From: Neeltje White [REDACTED]
Sent: 11 August 2020 17:29
To: Zac Denton <Zac.Denton@arun.gov.uk>
Cc: Martin Helyer [REDACTED] Richard Mole [REDACTED]
Subject: Riversong AB/72/20/HH

Re: Riversong, Arundel
Ref: AB/72/20/HH

River Song - Arundel - Proposed Arrangement

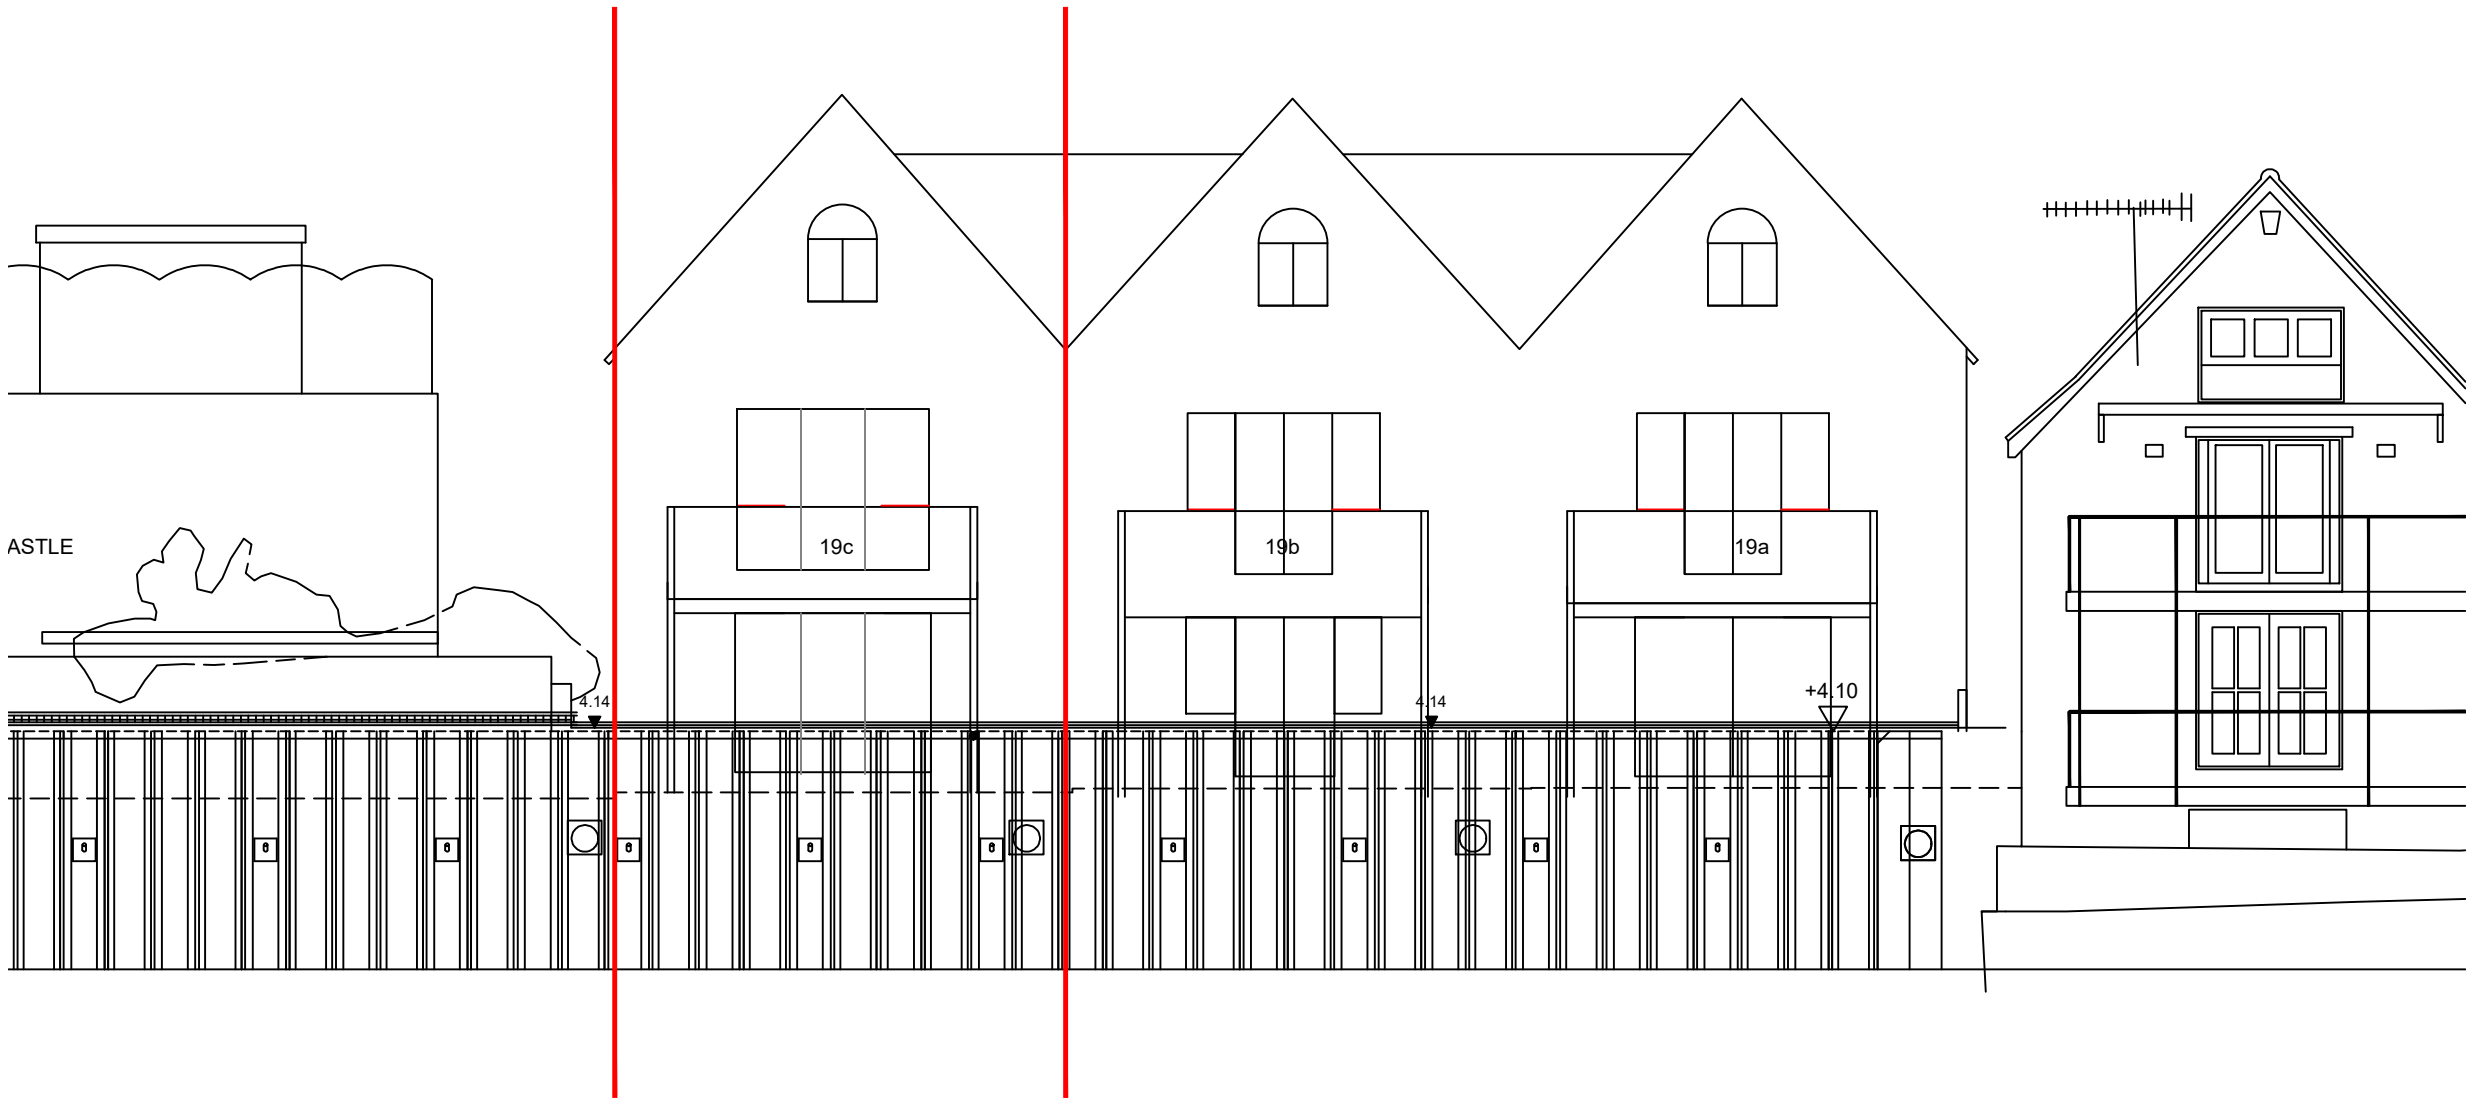
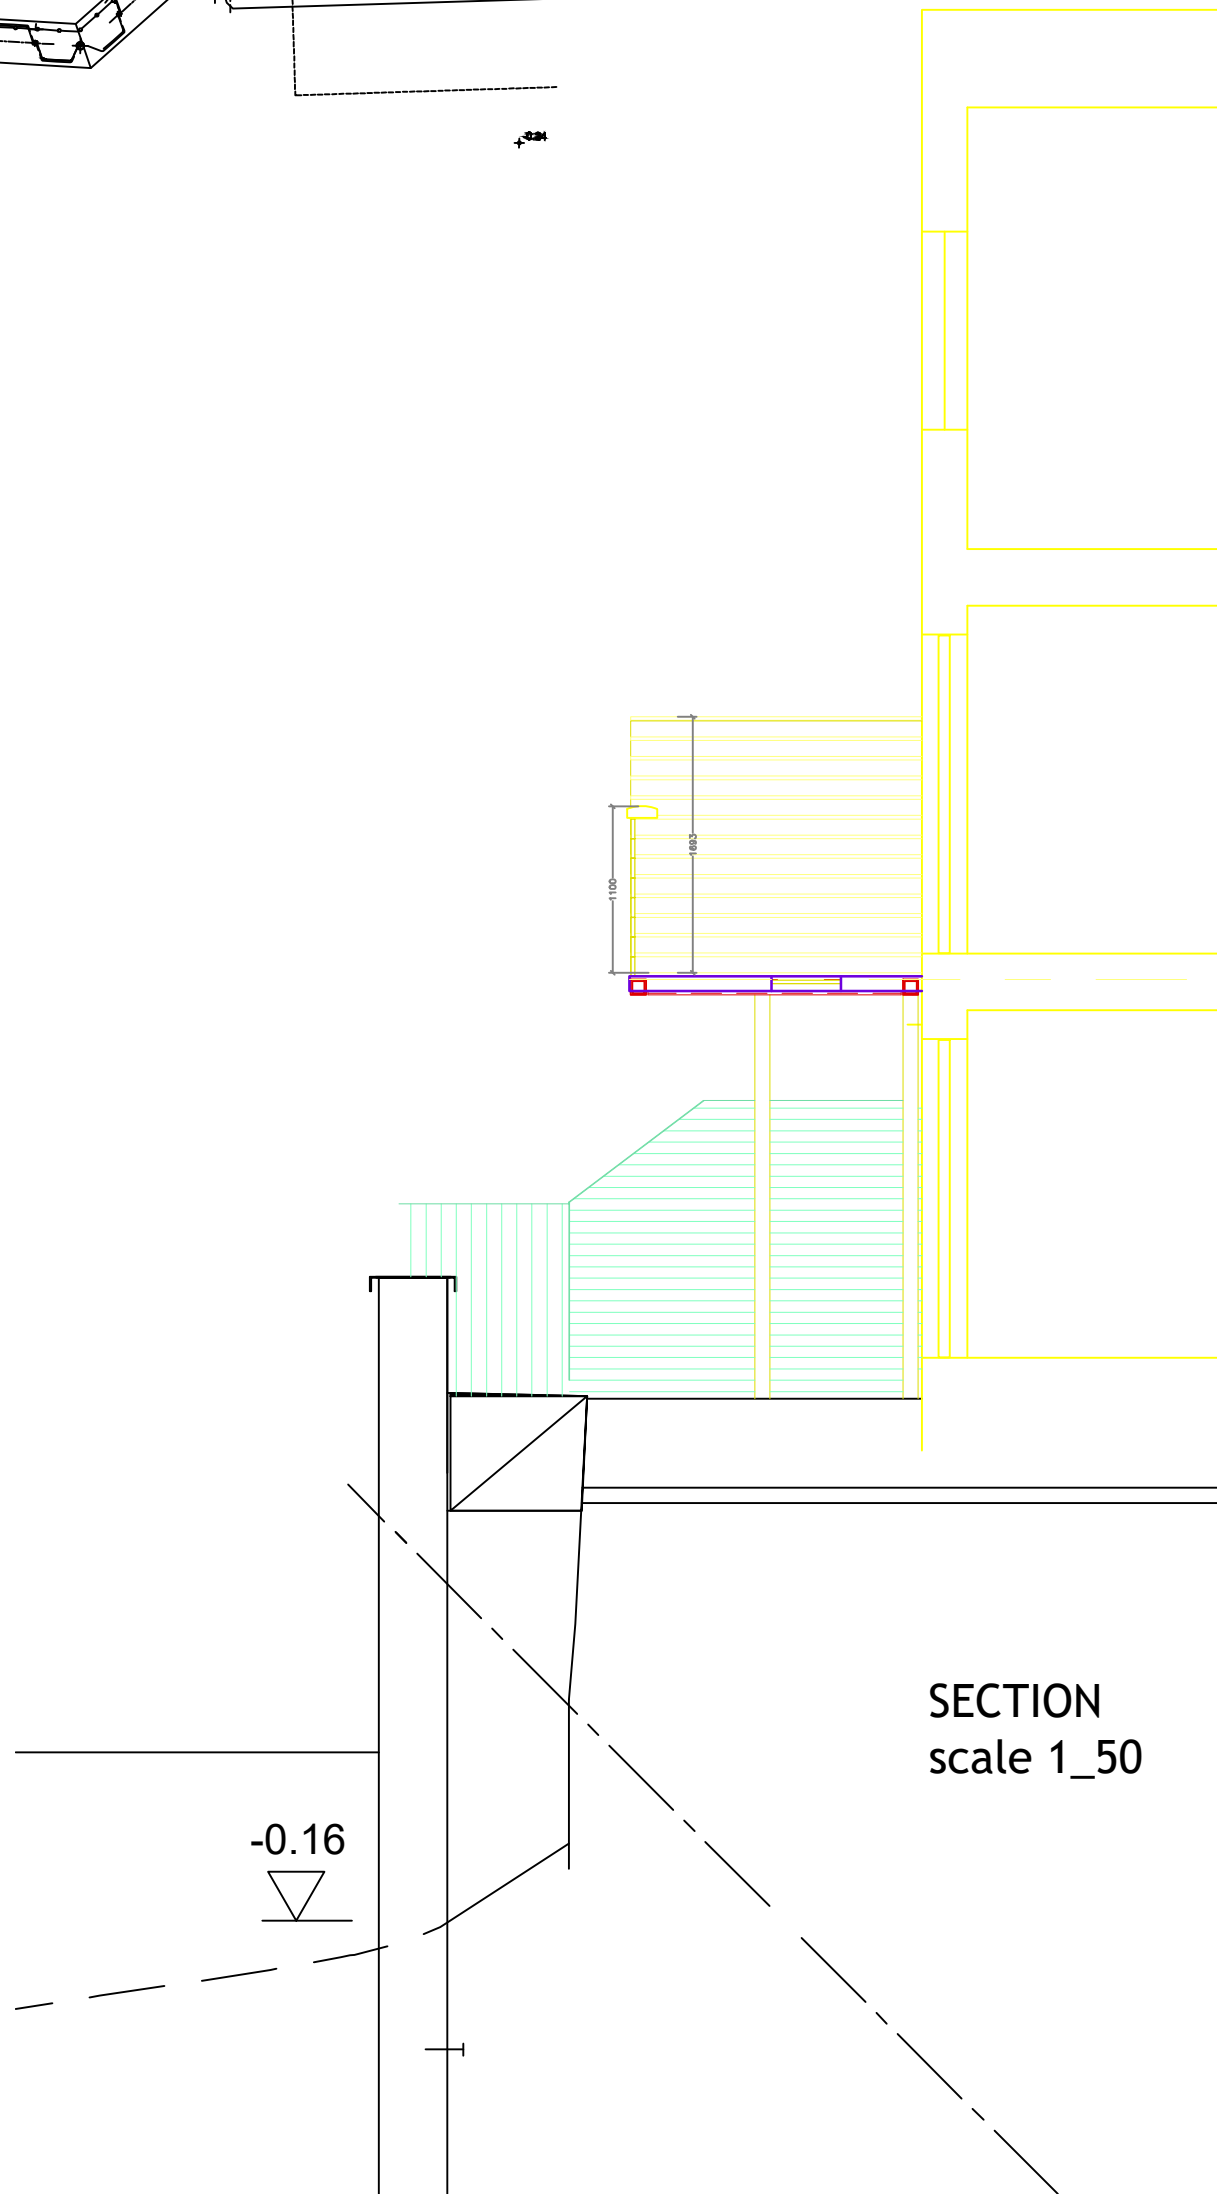
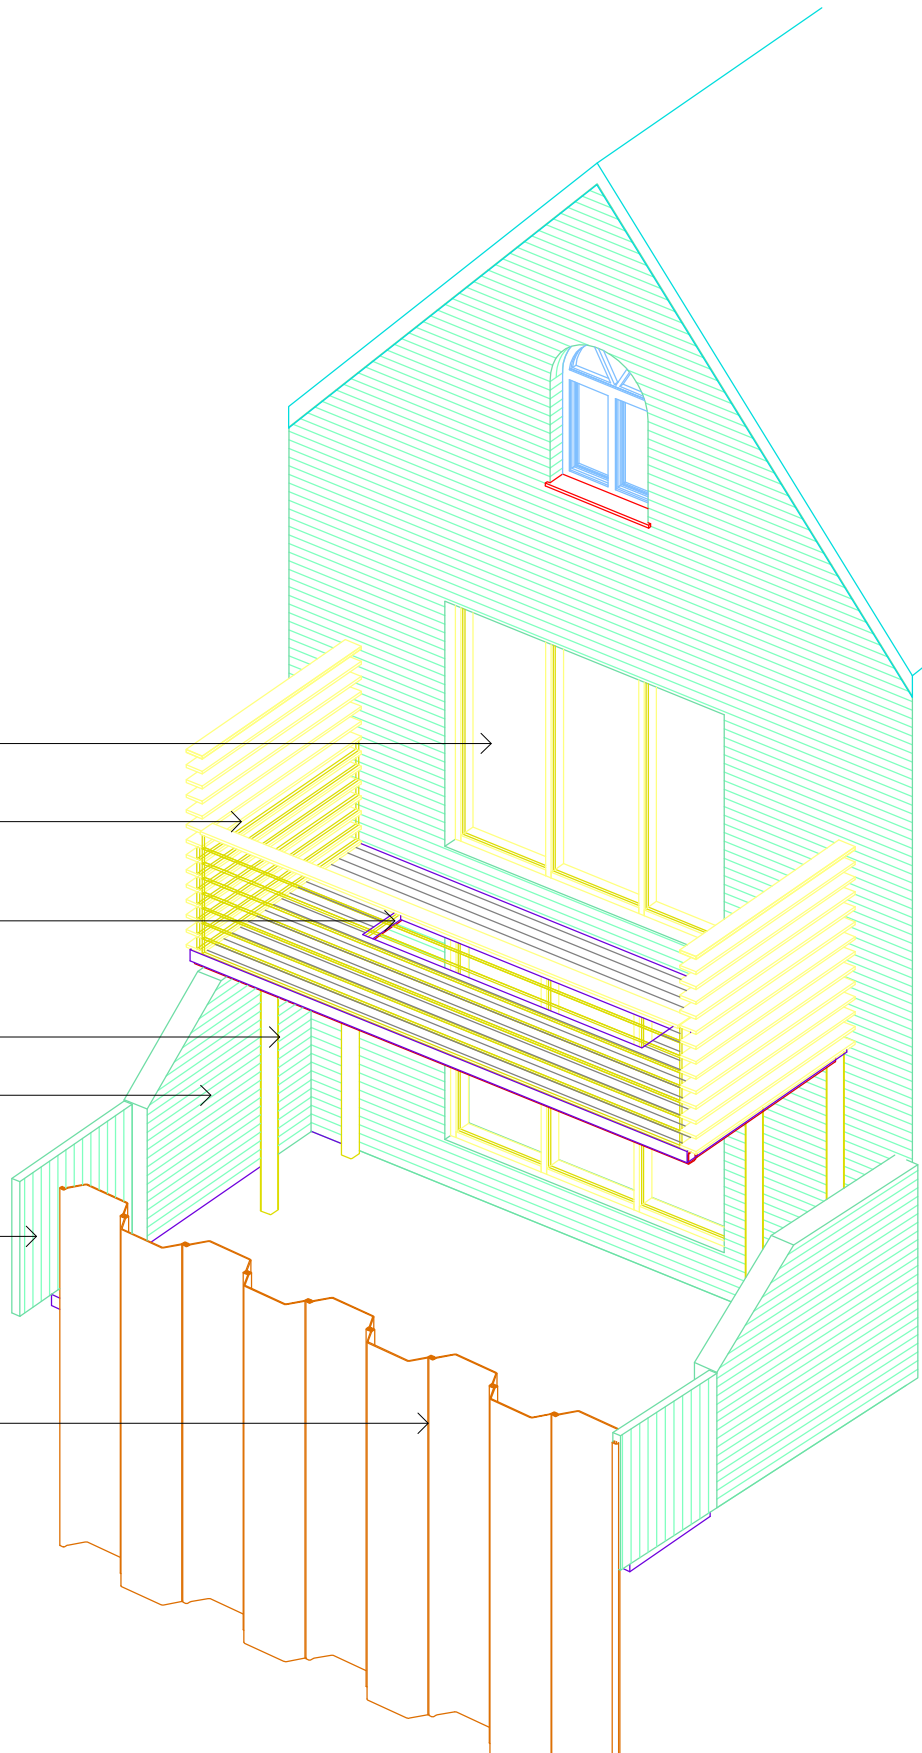
My call was in reference to the comments made by the Arun District Conservation Area Advisory Panel, in relation to the above application.

In response to the objections made, we would like to make the following comments:

- Need for high quality. The balcony that was removed was very low quality with a basic steel structure with industrial looking spiral staircase and basic tiles and metal hand rail. The proposed balcony will be of high quality steel / stainless steel, with teak effect wooden floor and wooden side panels. This is far more fitting and sympathetic with Arundel's warehouse / port history which was constructed of steel and wood (piles).

- The width of the proposed balcony is the same as the old balcony. The length is slightly bigger by 735cm. When looking directly at the rear of the building (from the houses opposite, the river and permissive foot path, which is very rarely used), this extra length will not stand out to an excess degree. It should also be noted that the balcony will be a very similar size and colour to the one on the Boat House (listed building) so will better reflect the style and materiality of this building.

- The proposed colour reflects that used on The Boathouse and the new build town houses directly opposite in the Beven Bevan & Co yard, which very closely reflect the design of 19A, B and C. This colour would be more consistently with the three town houses in the Bevan Bevan Yard as well as the boathouse in the surrounding context.

- We consider that the proposed colour, quality and size of the balcony would better reflect the and compliment the Boat House.
